Our Ref: EP/158/19/HH
Your Ref:

Development Demolition of existing garage & outbuildings, ground floor alterations to 2No. bay windows & fenestration & external materials alterations, erection of a new balcony, replacement garages & new dormer.

Location The Breakers 29 Tamarisk Way East Preston

1:100 West Elevation

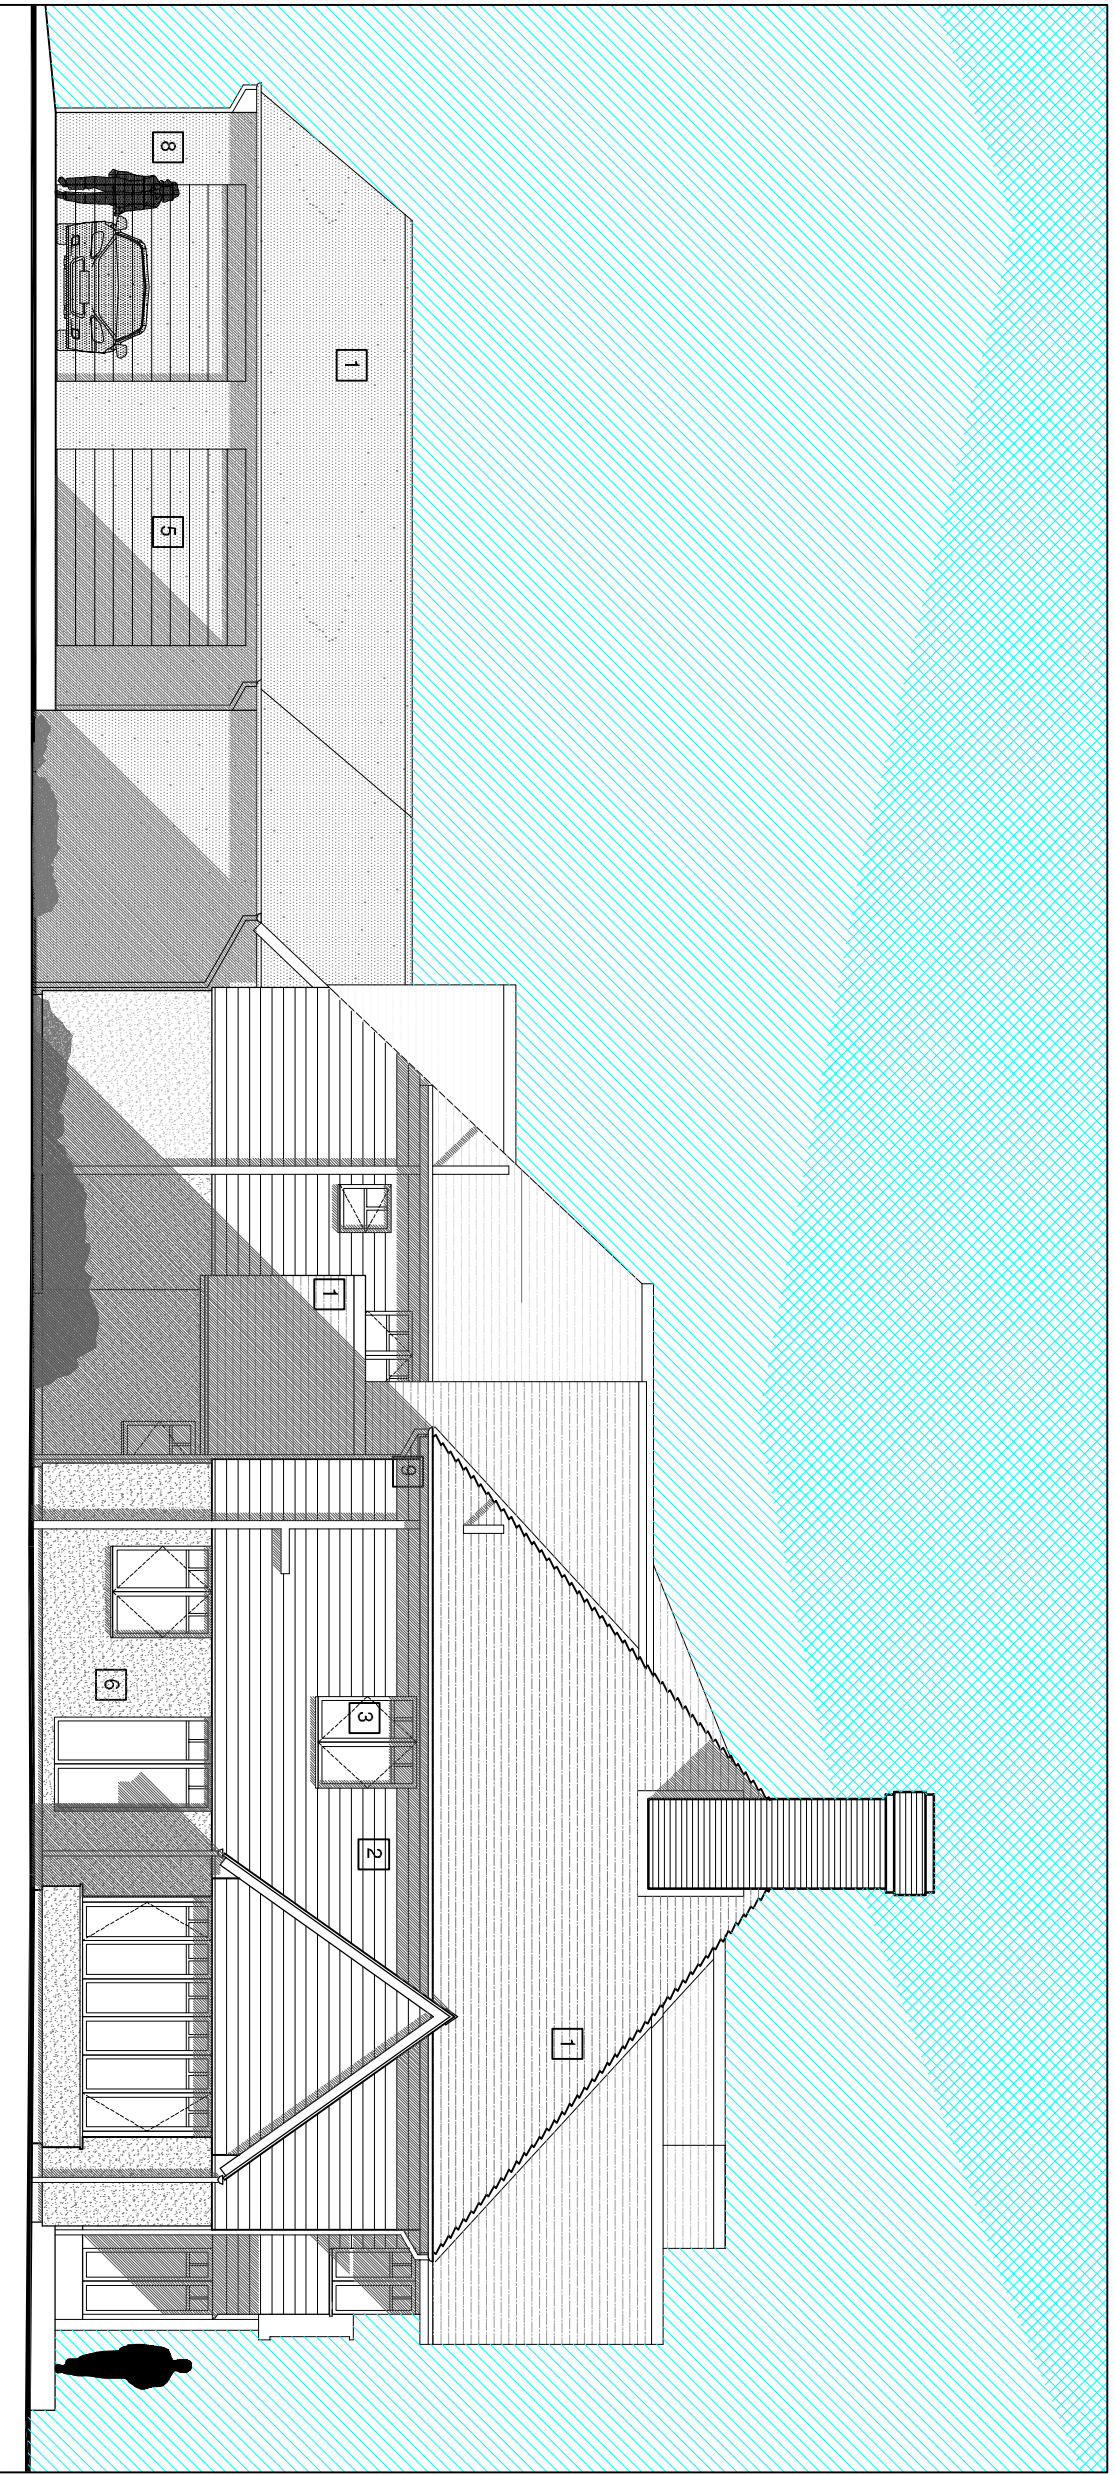
The proposed South elevation and second floor dormer window does not scale correctly. Please amend accordingly

1:500 Block plan as existing

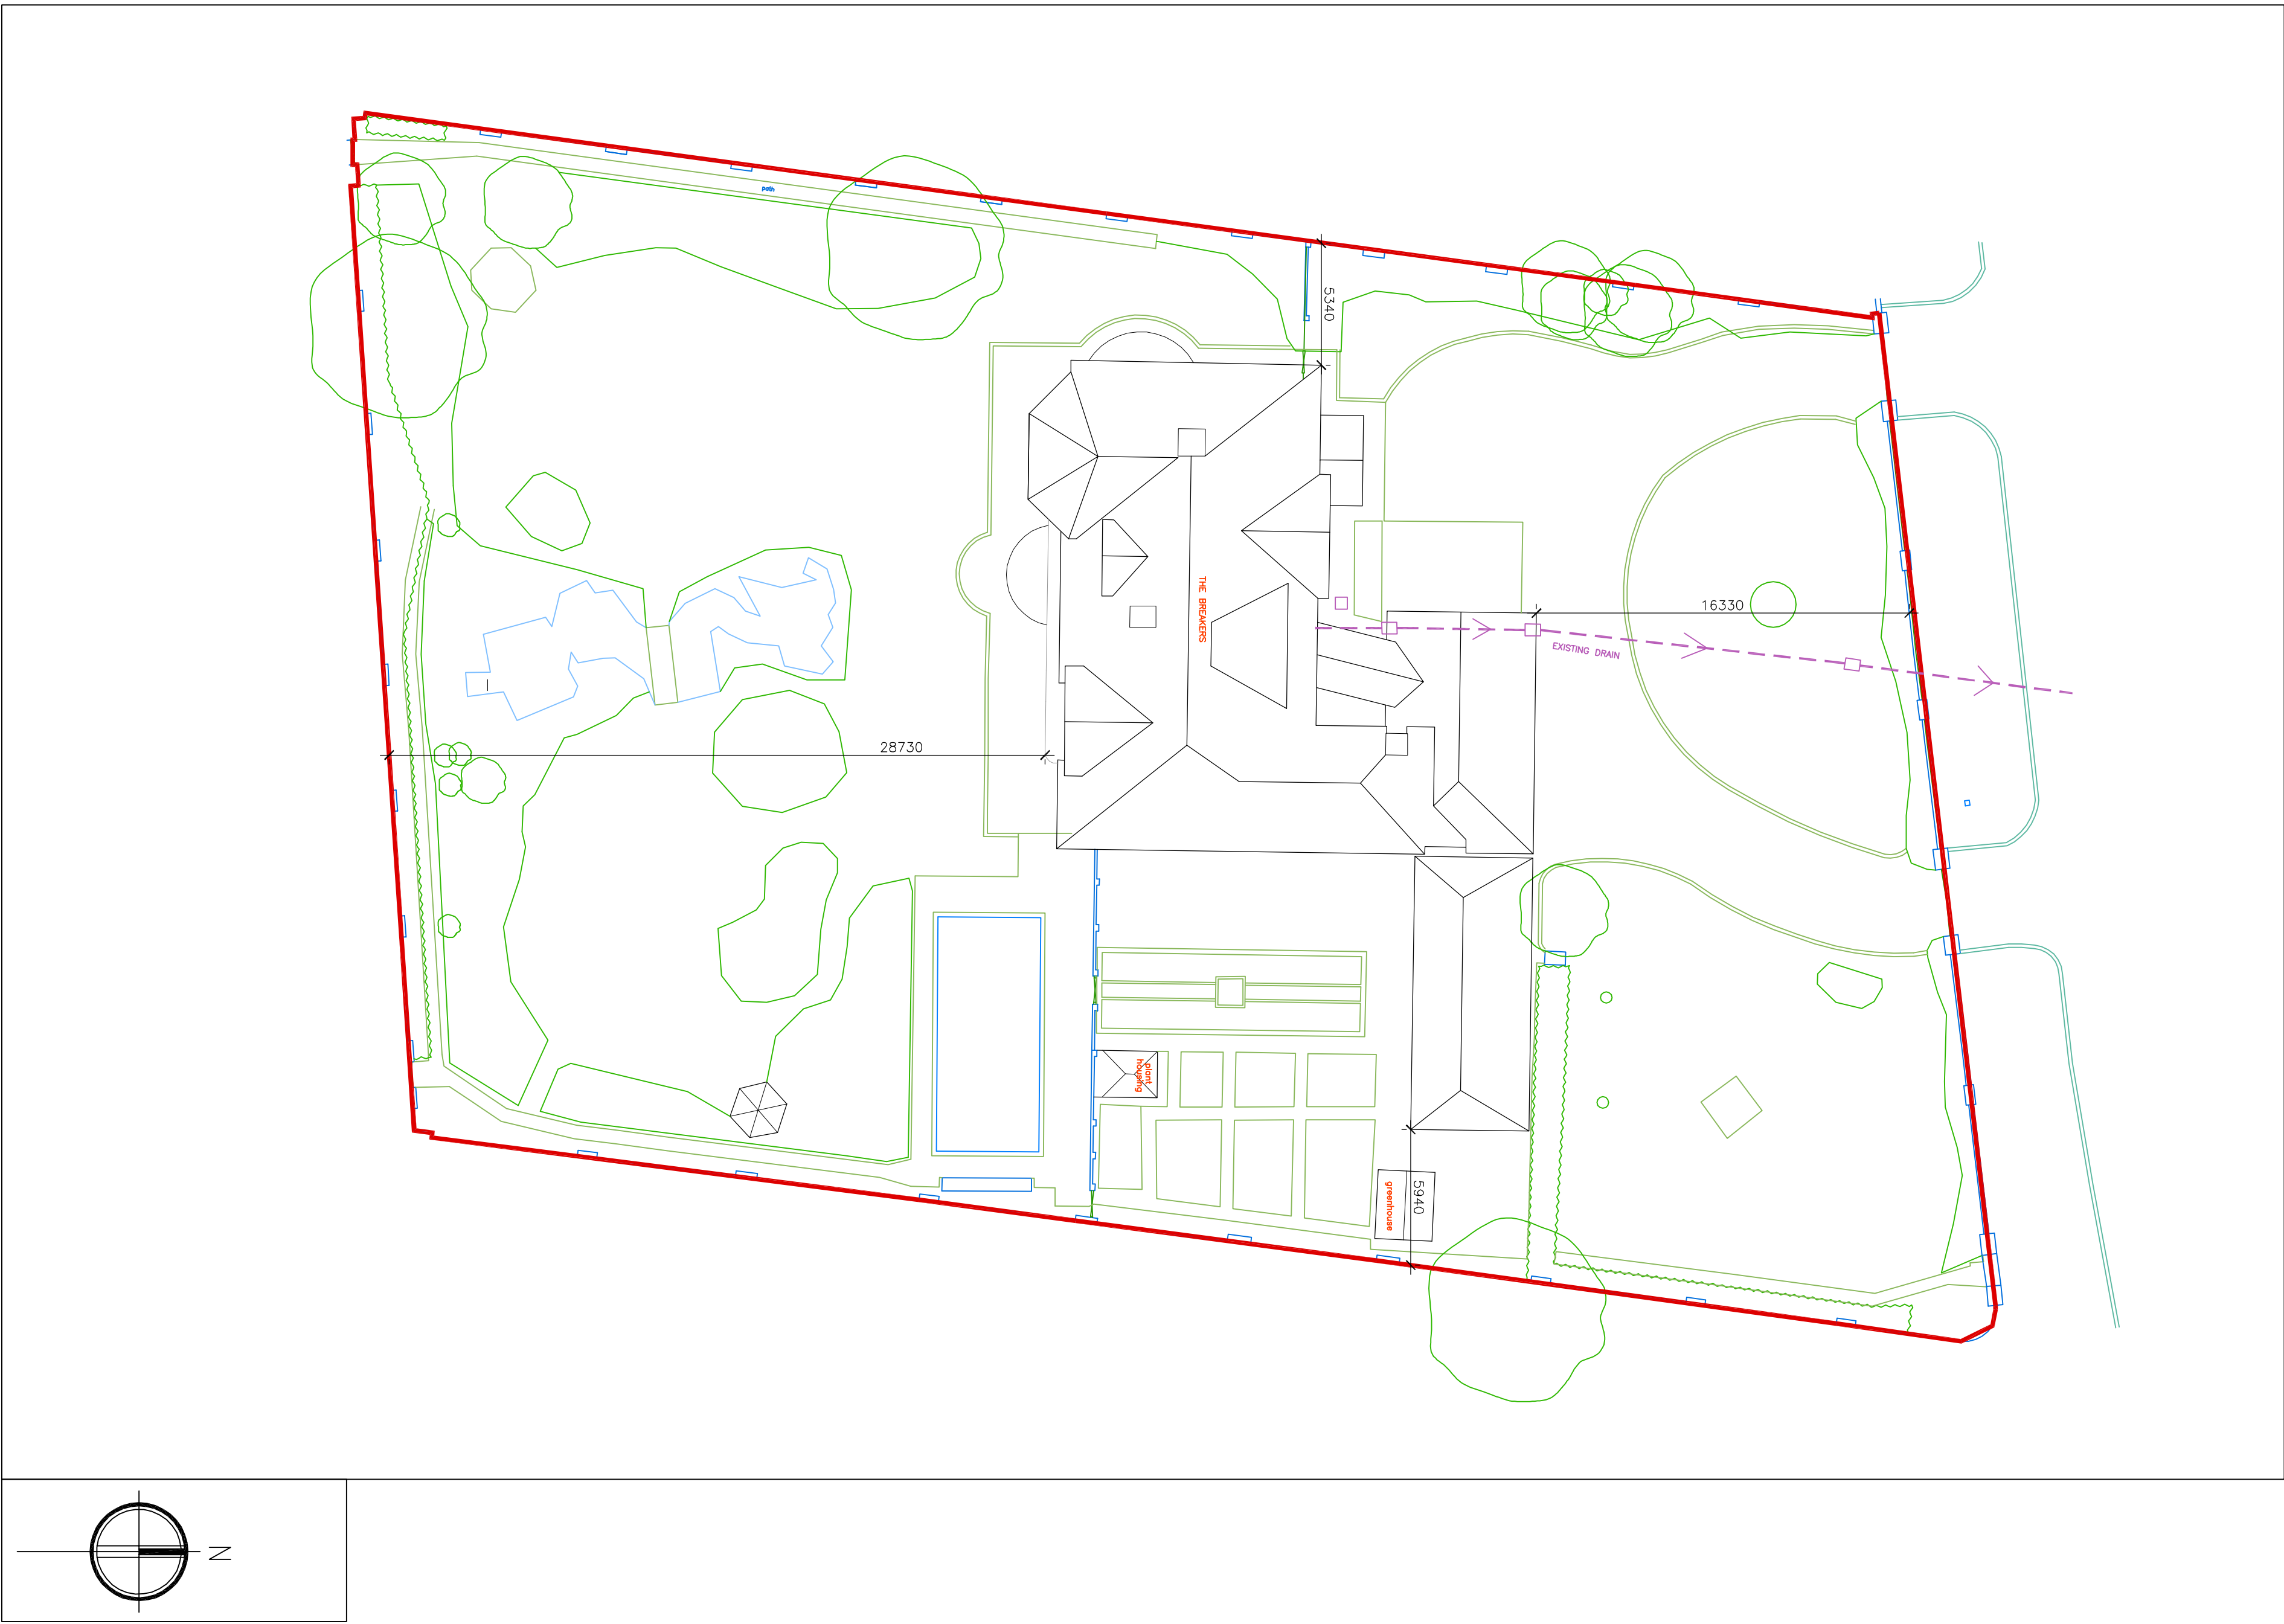
Proposed Block Plan Amend

Please clearly highlight all proposed works.
